## Response to Planning application from Hertfordshire County Council (T and CP GDP Order 2015)

District ref: 6/2022/1106/FULL  
HCC ref: WH/12320/2022  
HCC received: 20 May 2022  
Area manager: Matthew Armstrong  
Case officer: Steven Knight

1 LONGCROFT GREEN WELWYN GARDEN CITY AL8 6EP

Erection of 1 x detached 4 bedroom dwelling and detached 3 and a half storey building accommodating 6 no flats (4 x 2 bedroom and 2 x 3 bedroom flats), car parking, refuse and recycling bins enclosure, secure cycle storage, turning heads and use of the existing vehicular access following the demolition and removal of a pair of semi-detached dwellings.

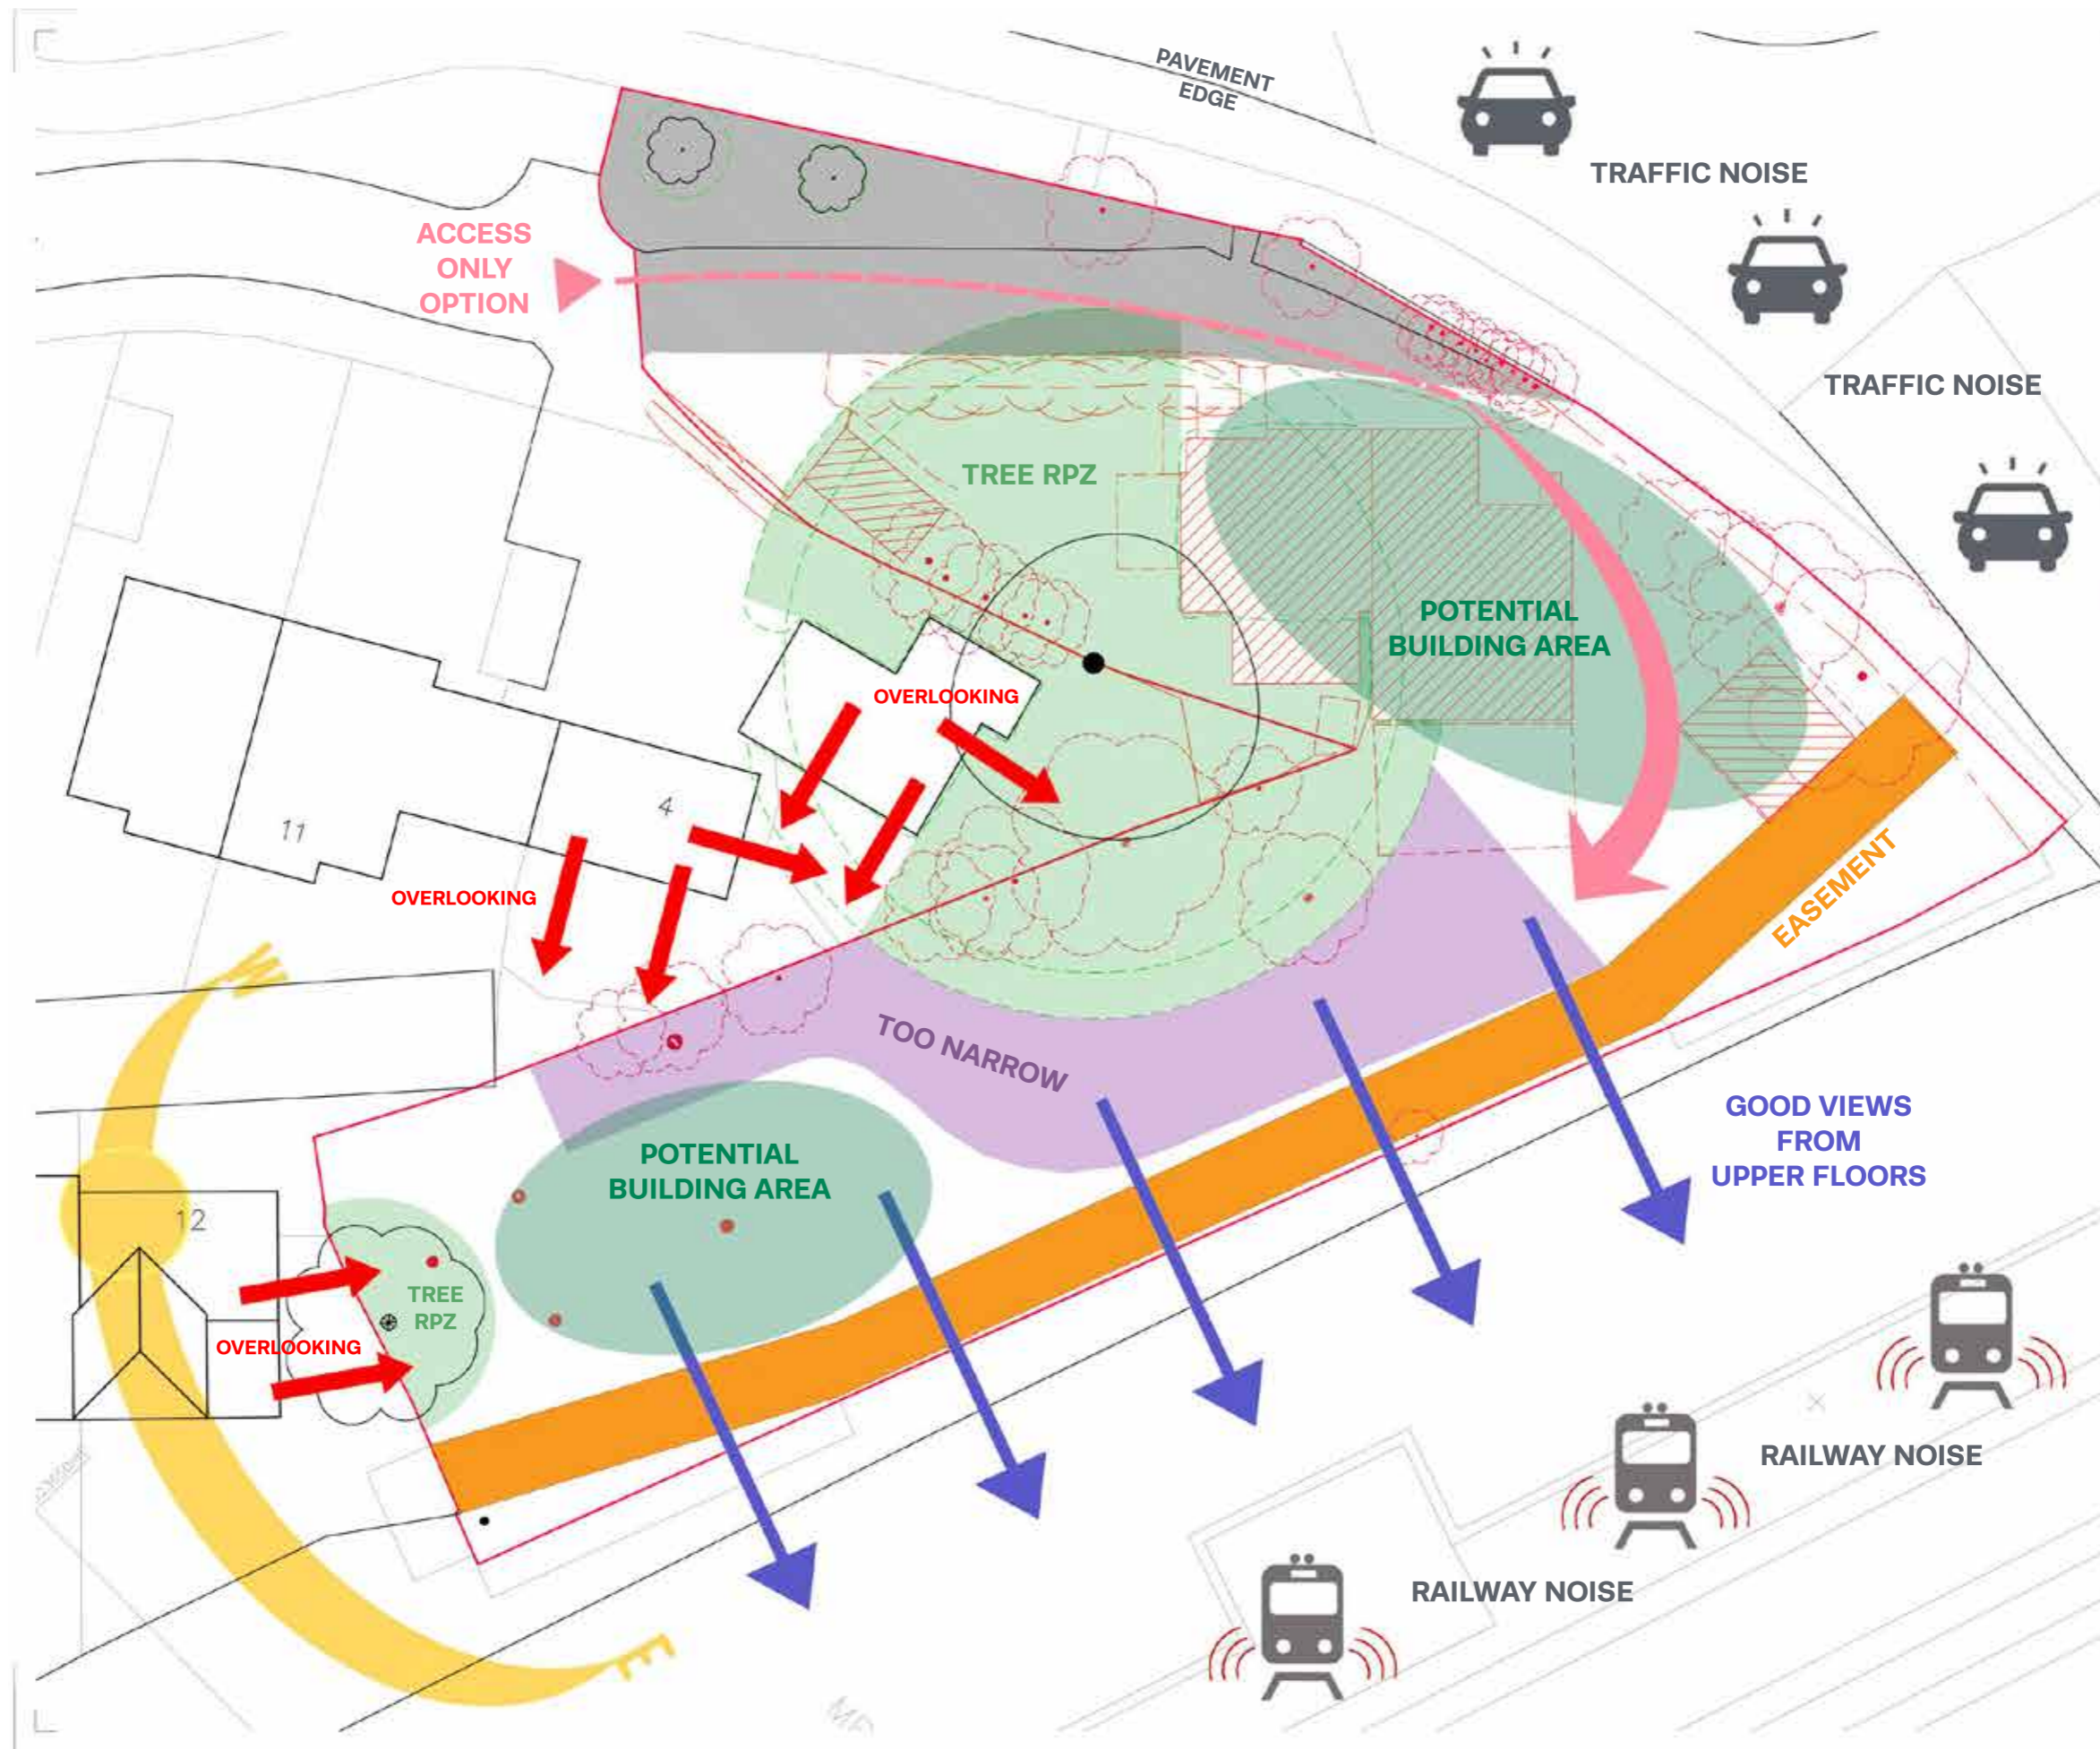
Thought should be given to the landscaping on the inside of the bend to ensure that it does not obstruct forward visibility around the bend. Similarly, vehicles leaving the site need to have adequate visibility of vehicle leaving Nos. 3 & 4 Longcroft Green and vice versa. This appears to be obstructed by the proposed hedge row.

It is noted that part of the site appears to be on highway land. The application does not state whether there is any 'stopping up' or dedication intended. Any work on the public highway would be subject to a S278 agreement with HCC and need to be constructed to highway standards. The extent of the highway will also need to be demarcated on-site as part of the final scheme. It appears that that existing highway boundary extends slightly further south than is shown on drawing 192 101.

The existing stretch of Longcroft Green consists of a tarmac carriageway with no footway and this arrangement appears to extend into the proposed development, but this is not acceptable based on current standards and prioritises the motor vehicle above pedestrians. If the development will be a shared surface then this needs to be clearly defined. Paragraph 3.5 of the Transport Statement suggests that a footway will not be provided but that pedestrians will not have to walk in the carriageway, but this seems unfeasible. Further information needs to be provided about which routes pedestrians will be expected to use.

It's also unclear what the main pedestrian route is into the site. It cannot be via Longcroft Green unless a footway is provided. The Site Plan appears to show an access from the shared footway/cycleway to the north of the site, but this is less than a metre wide. Pedestrians would then be required to give way to vehicles and it's not clear what route they would take to enter the building.

A cycle store is shown on the Site Plan and the Transport Statement states that it will provide 12 spaces (two per flat), which would be acceptable. Further details of the cycle store should be conditioned to ensure this is achievable as the store is only 3.3m wide. The house will benefit from a garage which can be used for secure cycle storage.
